Arun District Council
Arun Civic Centre
Maltravers Road
Littlehampton
West Sussex, BN17 5LF

07 March 2016

ADC Ref: P/97/15/PL
MMO Ref: MLA/2015/00390
CDC Ref: SY/15/03053/FUL

Re: Planning Application and application for Marine Licence by Pagham Parish Council for managed breach of shingle spit, blocking of adjacent tidal inlet channel with shingle barrier and formation of Shingle Island within Pagham Harbour following excavation of adjacent area of spit

Figure 2

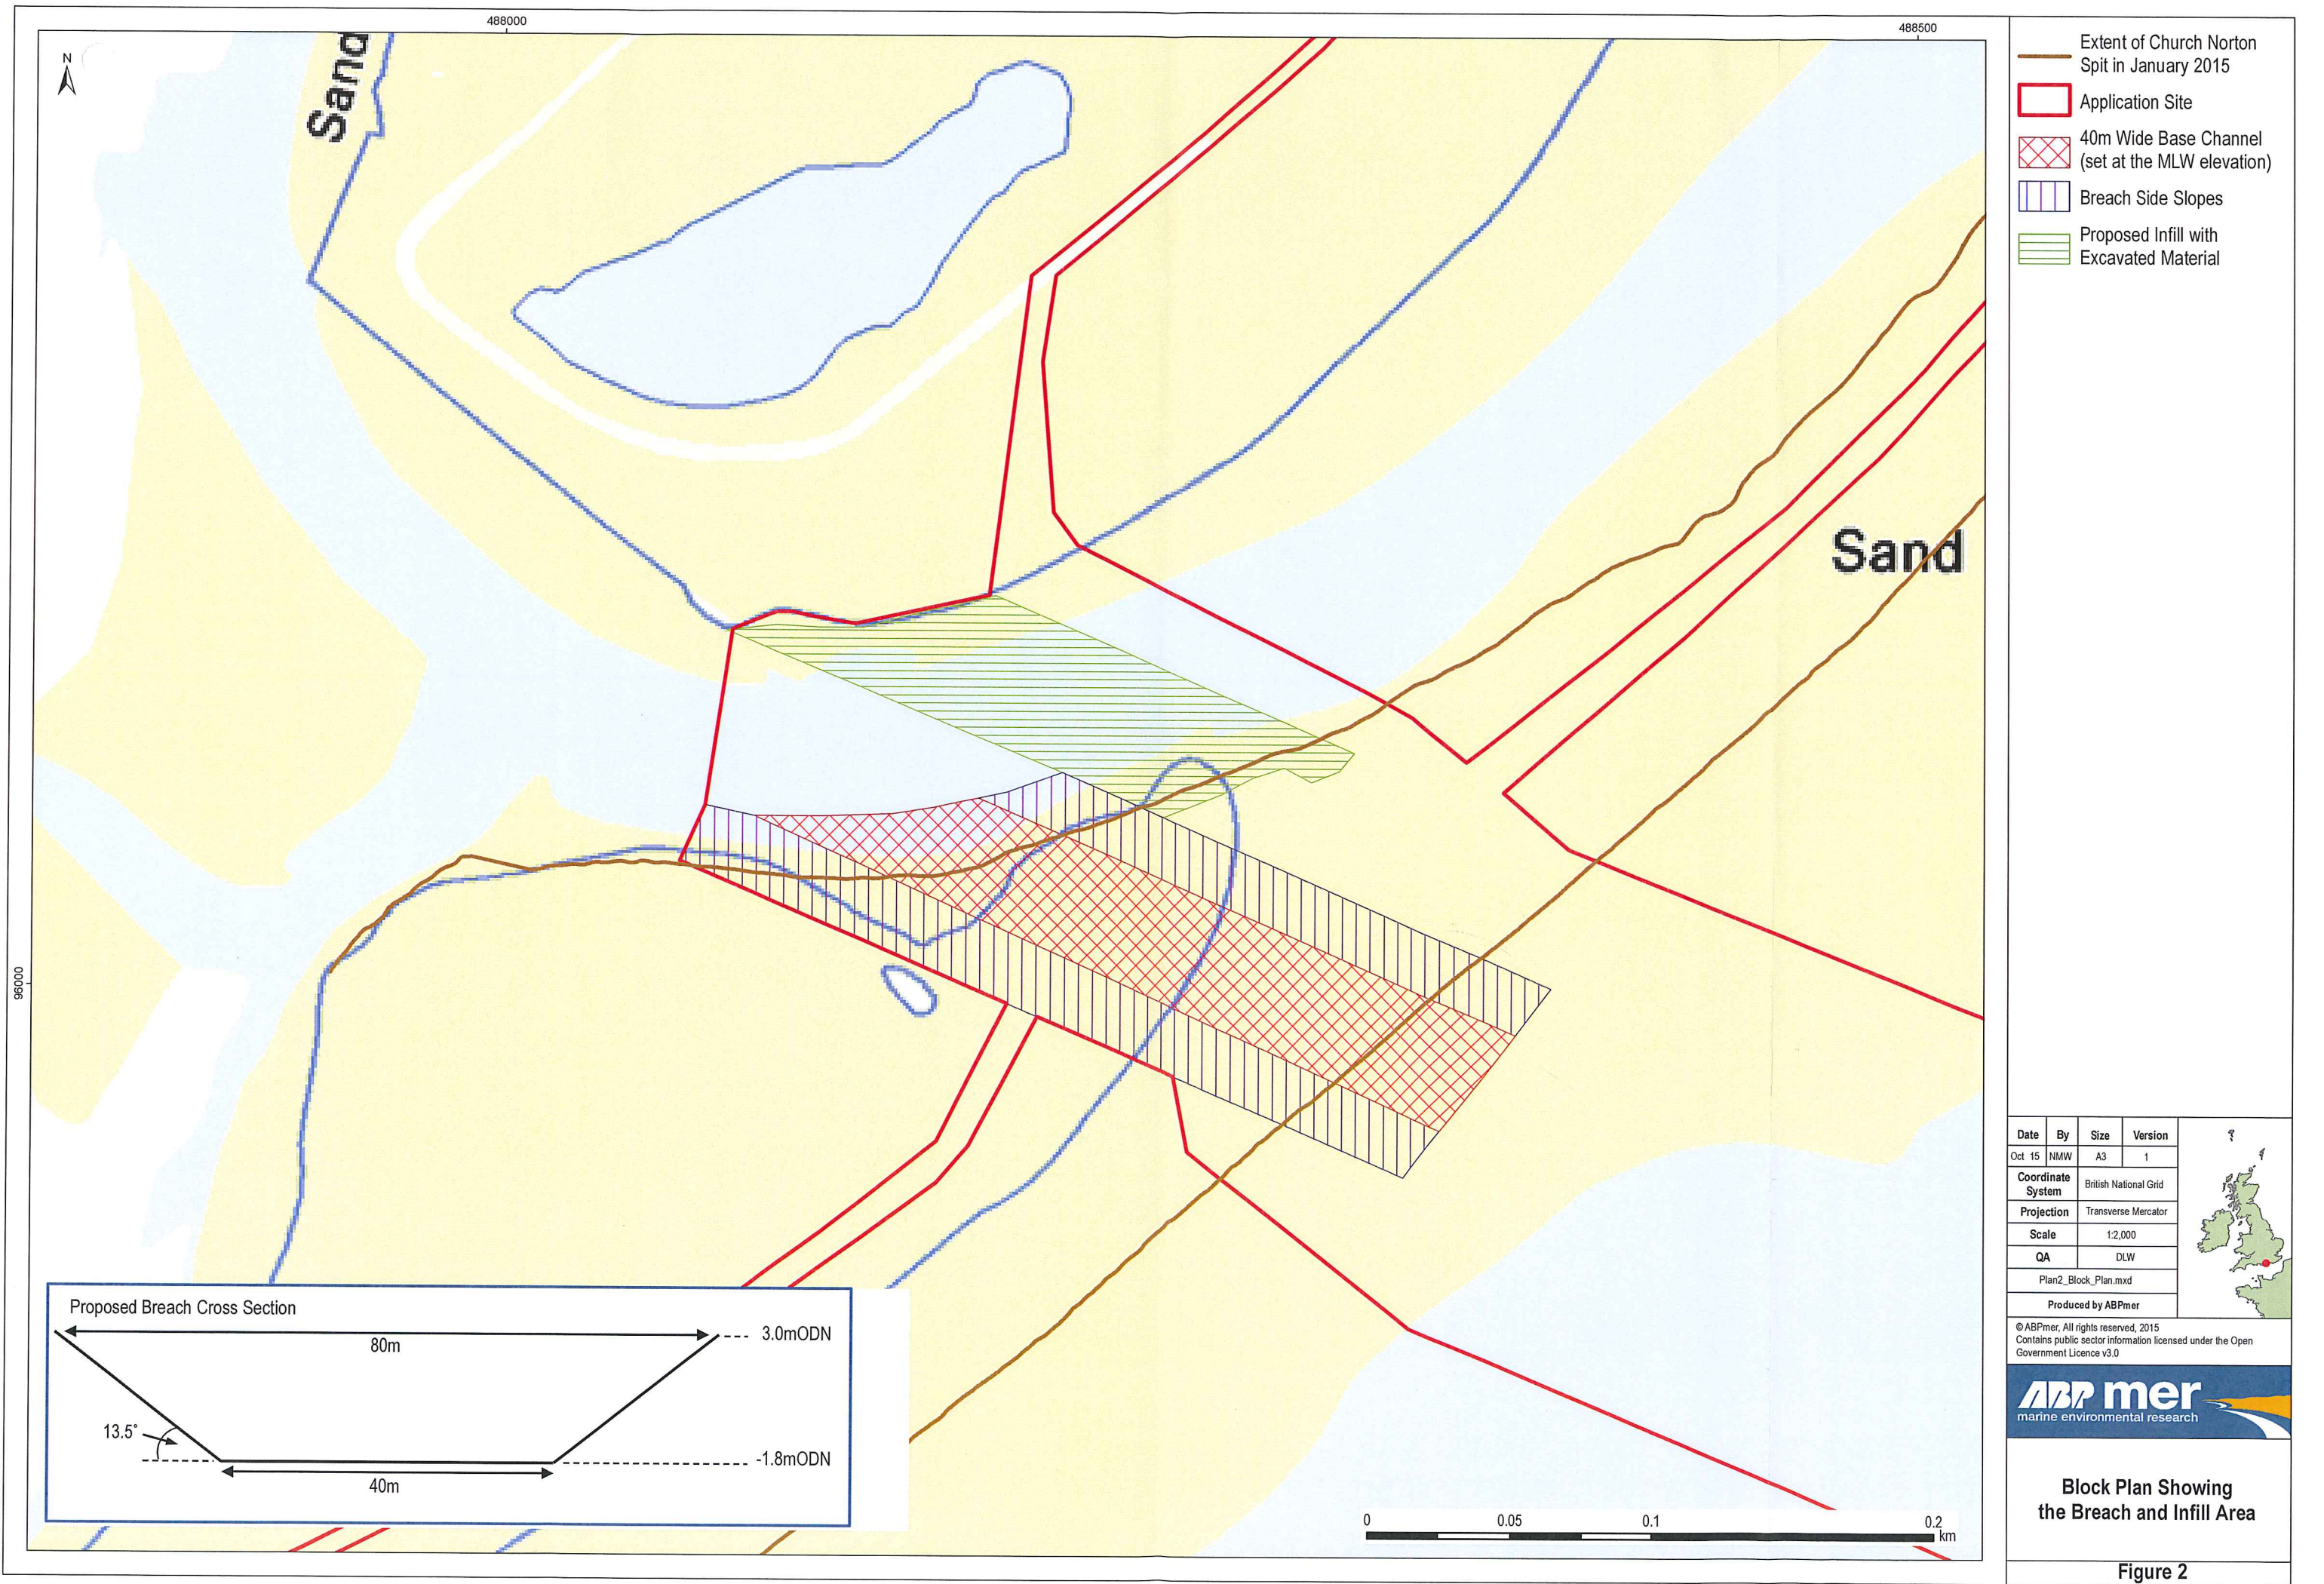
Finally, I believe that my Team Leader, Daniel Vick spoke to you after the meeting regarding providing drawings that are truly representative of the proposals. It is noted that the submitted plans show an apparent discrepancy in that Figure 2 shows a consistent 40m wide base channel with 20m on each side of the breach for side slopes (a total width of 80m). However Figure 4, Profile A appears to show a total width of 150m which is some 70m more than would be anticipated from an examination of Figure 2. Are you able to provide an explanation for this? If the plans need amending then please provide these within 21 days of this letter.

Figure 4

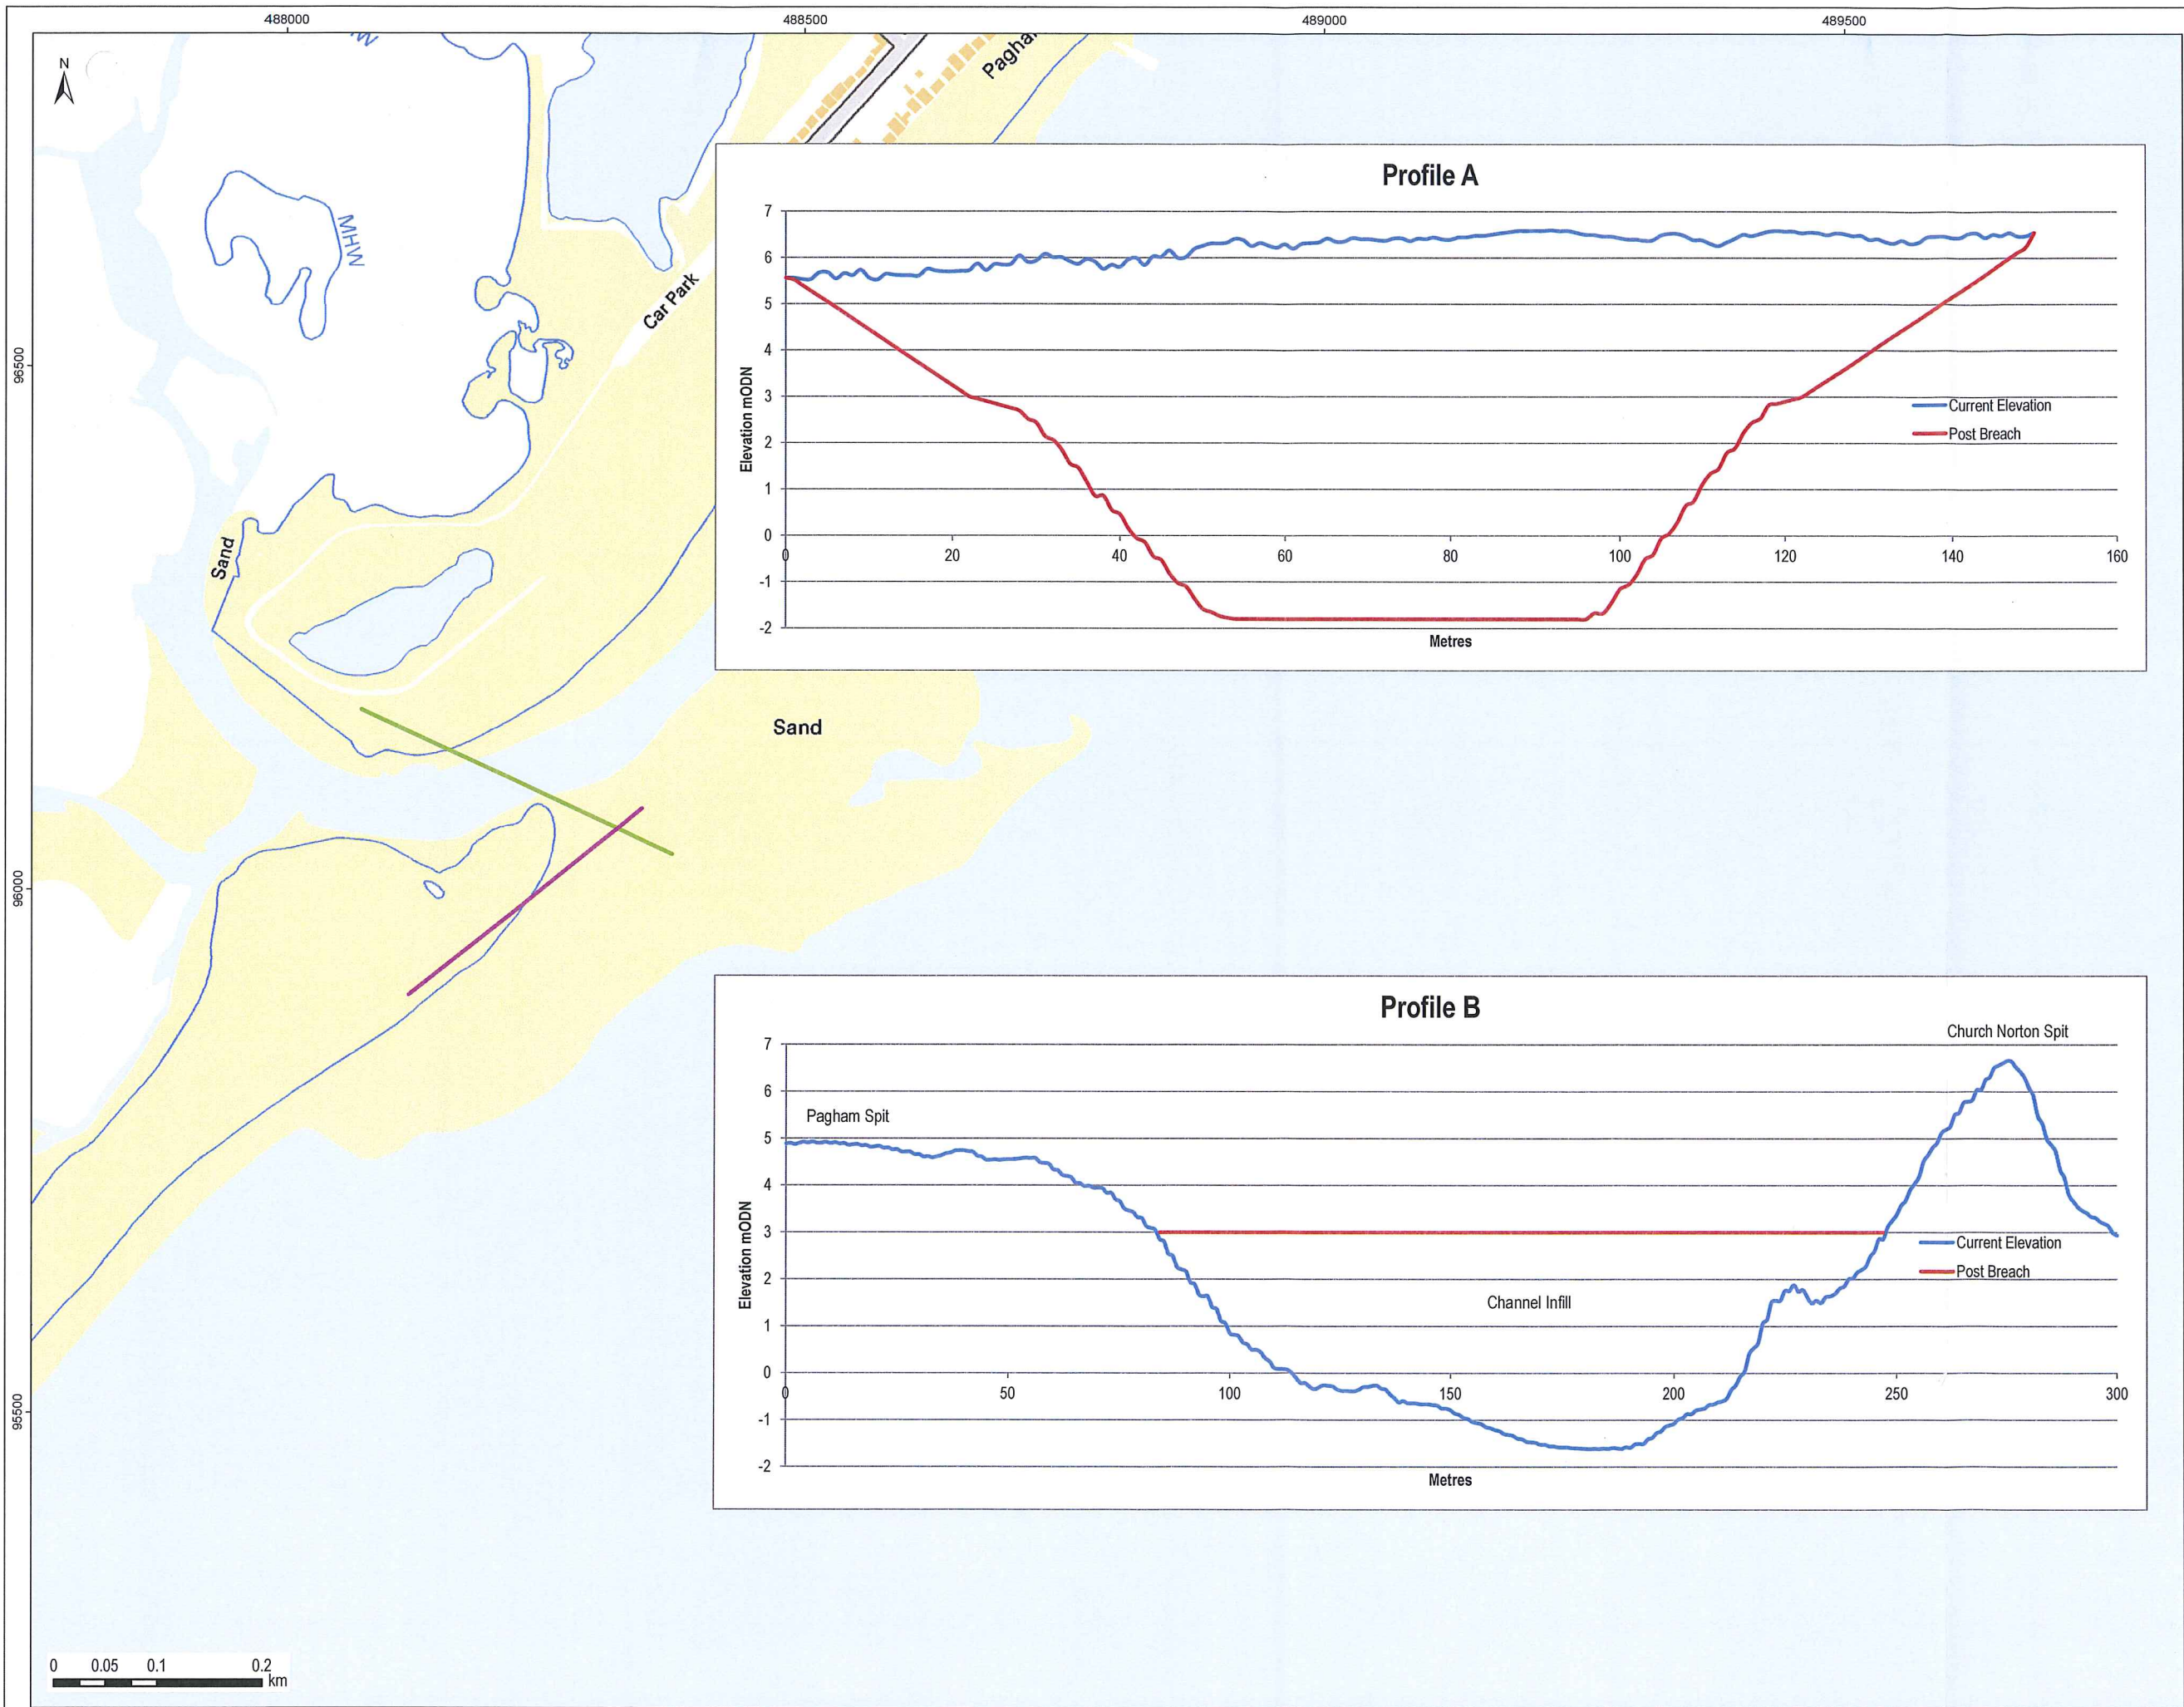
ADC Engineers have also indicated that they have previously verbally asked you for detailed 'cut and fill' calculations (and the topography of the spit at the relevant locations), together with allowances for construction losses, in order that the viability of the proposed operation can be assessed. It is understood that we have so far only had very outline figures and we need the detail to be able to properly assess the proposal.
